Application for a Non-Material Amendment Following a Grant of Planning Permission

Demolition of an existing detached bungalow and the erection of 2no. dwellings and alteration to access (Re-submission of 23/03676/FUL).

23/04739/FUL

We seek to amend the proposed roof material from 'red/brown clay roof tiles', as stated in the approved application form and Design and Access Statement, to instead be 'natural slate'.

JOB NO.	DRAWING NUMBER	REV
727	PL-15	B

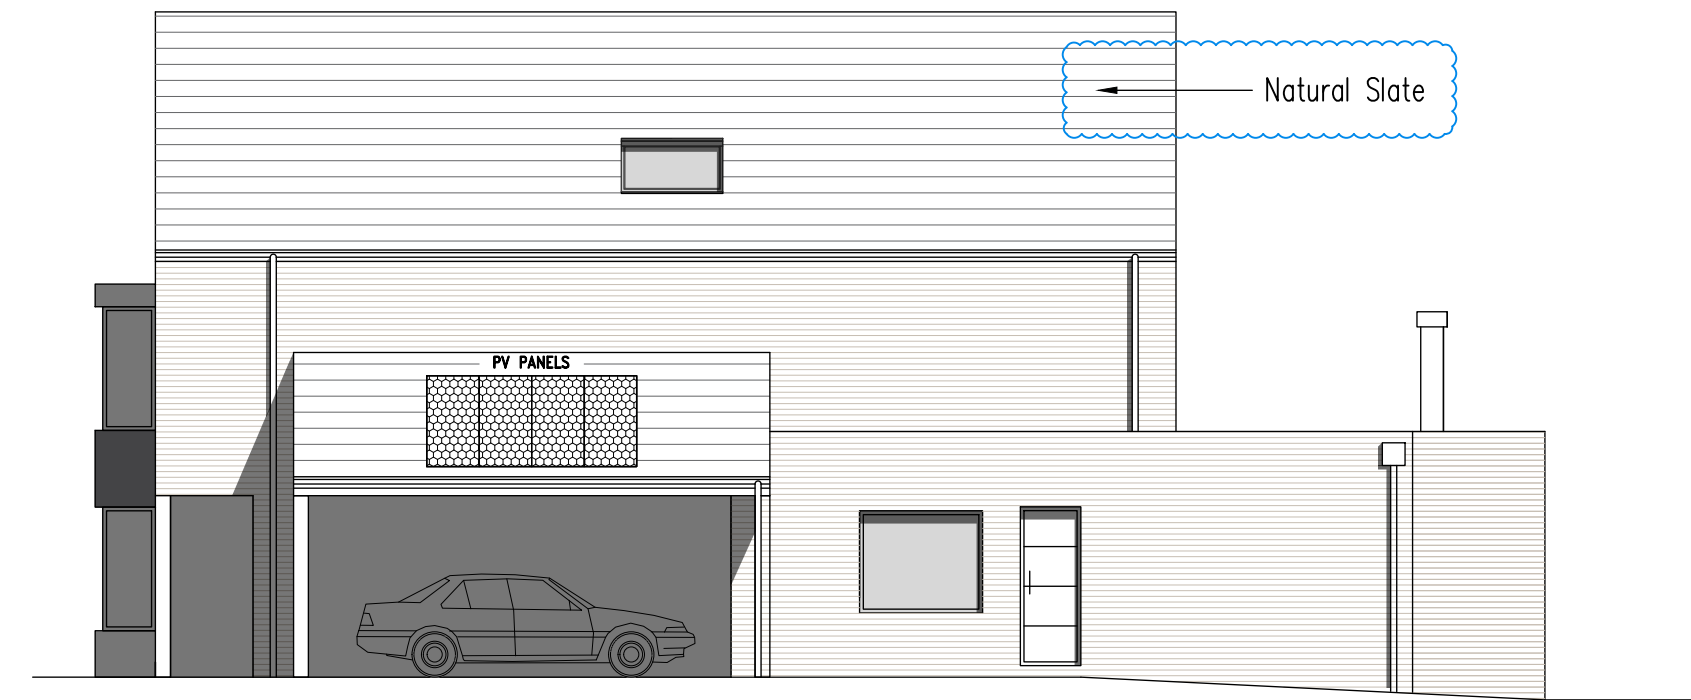
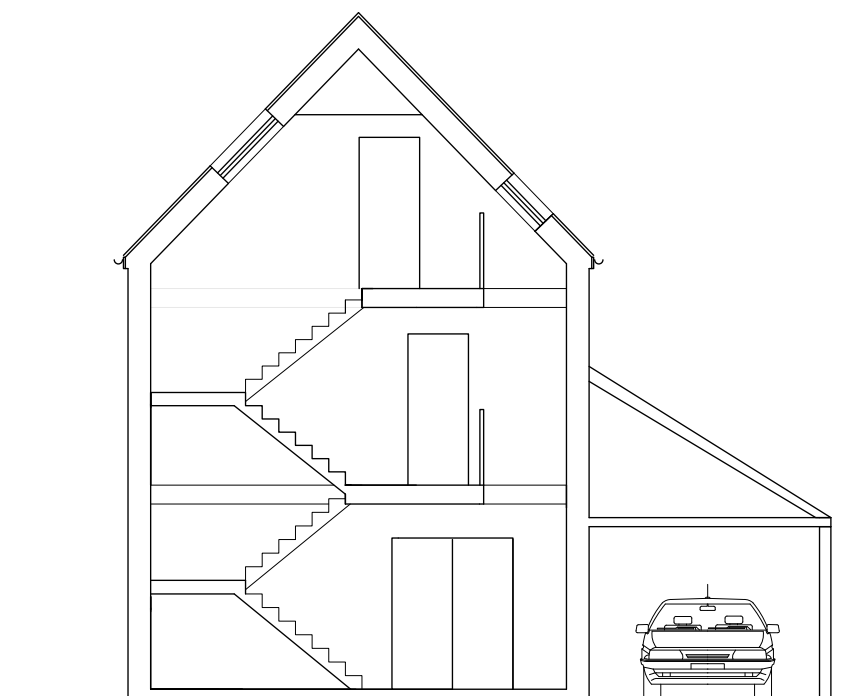
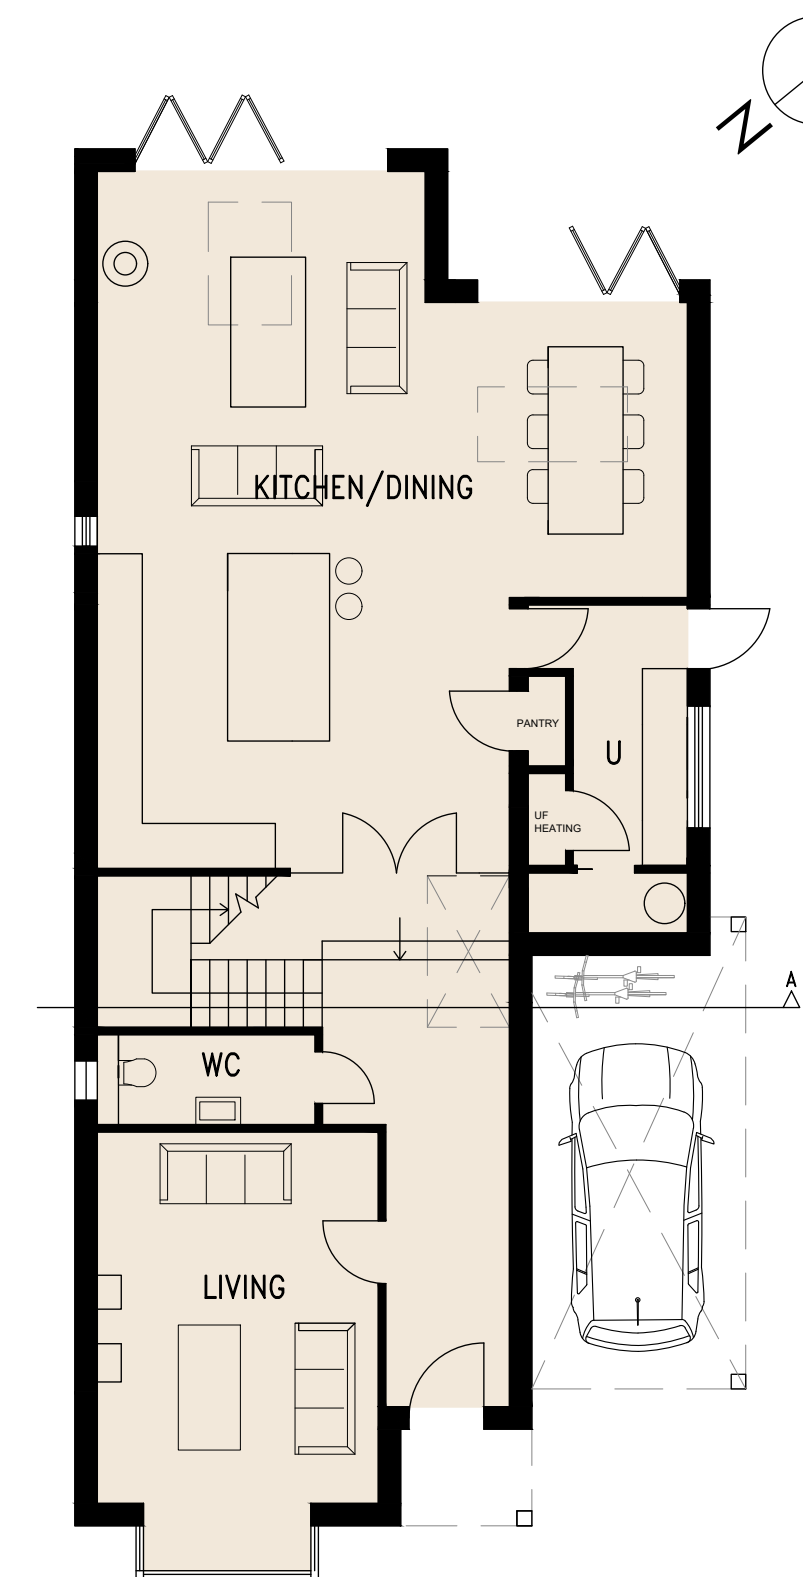
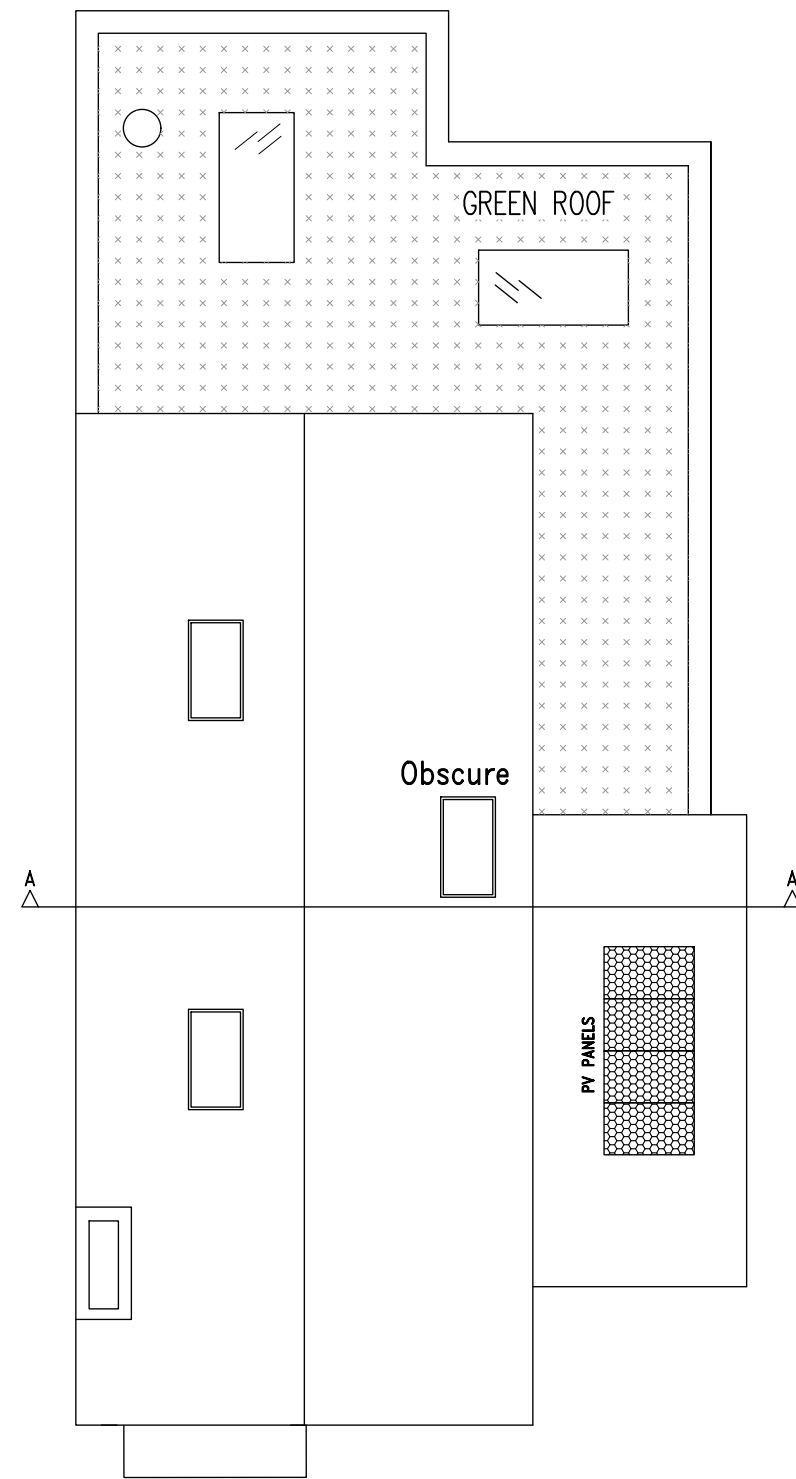
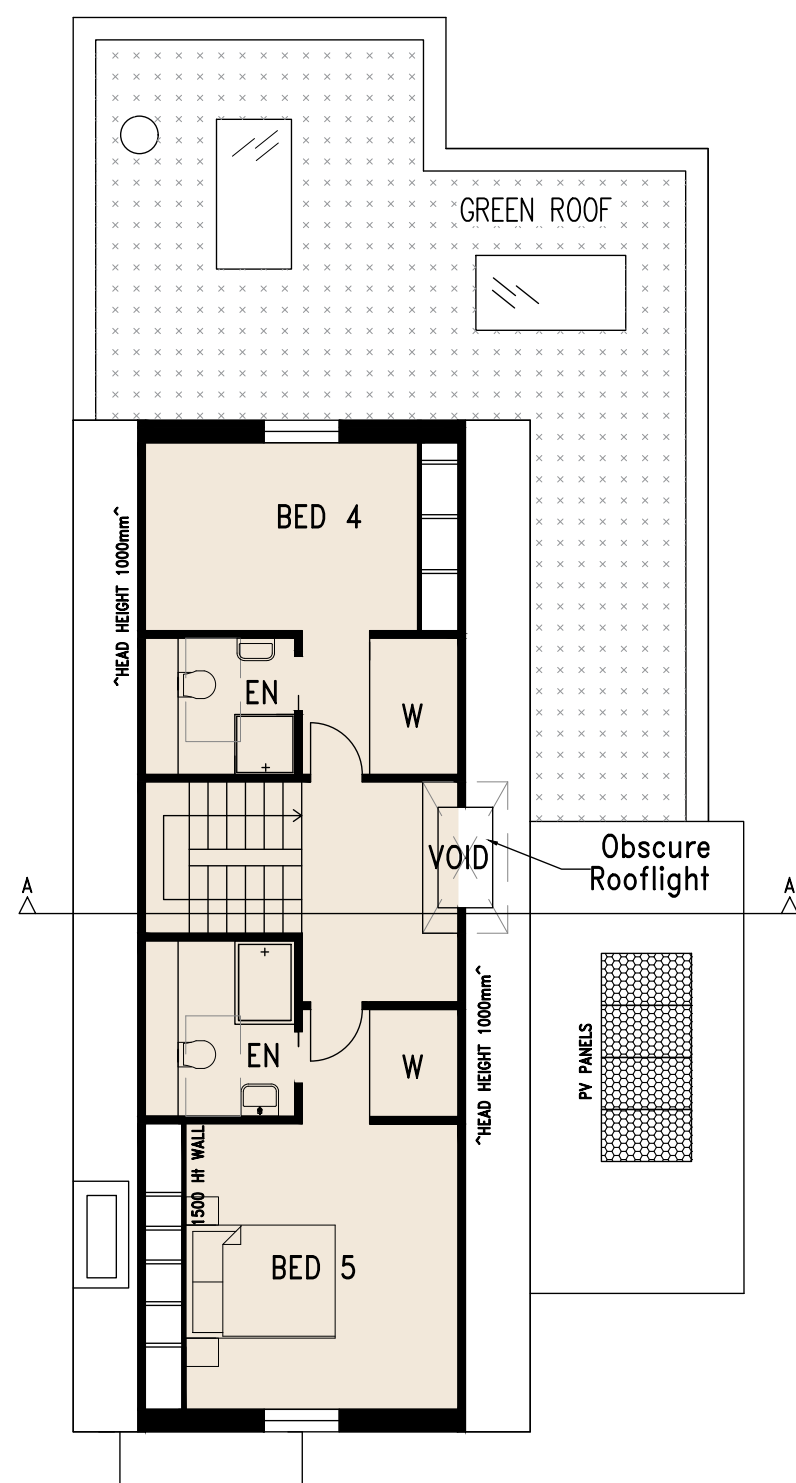
To improve visual appearance. It should be noted that many of the surrounding dwellings also feature slate roofs.

PL-14B: Proposed Plot 1: Floor Plans, Elevations and Section
PL-15B: Proposed Plot 2: Floor Plans, Elevations and Section
